Ribble Valley  
Borough Council

My reference: 3/2022/0094

**TOWN AND COUNTRY PLANNING (GENERAL PERMITTED DEVELOPMENT) ORDER 2015  
PARTS 6 PRIOR NOTIFICATION OF AGRICULTURAL AND FORESTRY BUILDINGS AND ROADS**

Proposal: Proposed new buildings Unit 1 and Unit 3 to provide storage of animal feed to include hay/straw and machinery.

Drawing Title
 PROPOSED FLOOR PLAN
 (UNIT 1)

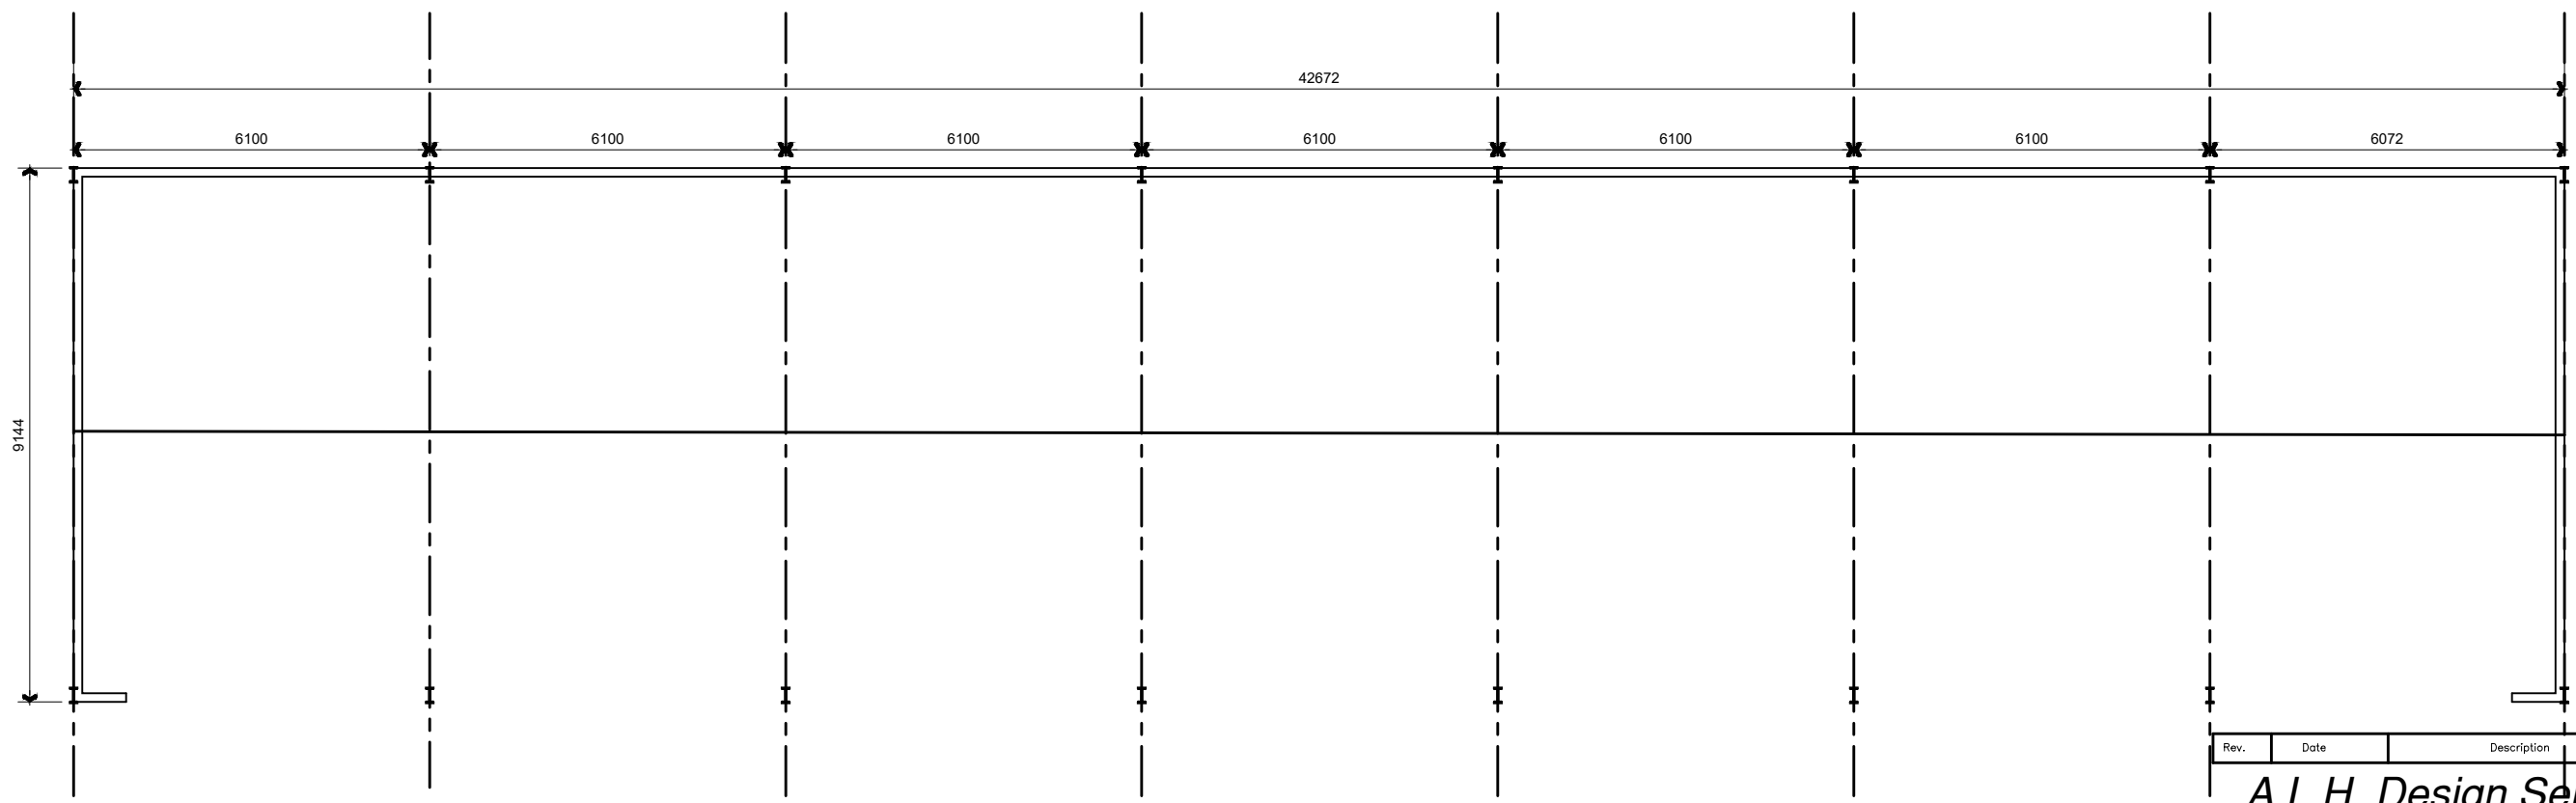
- 1 The proposal does not meet the criteria set out within Part 6, Class A of the Town and Country Planning (General Permitted Development) Order 2015 as the ground floor area covered by the proposed agricultural buildings would exceed 1000m<sup>2</sup>. Accordingly, prior approval is refused and a full planning application is required.
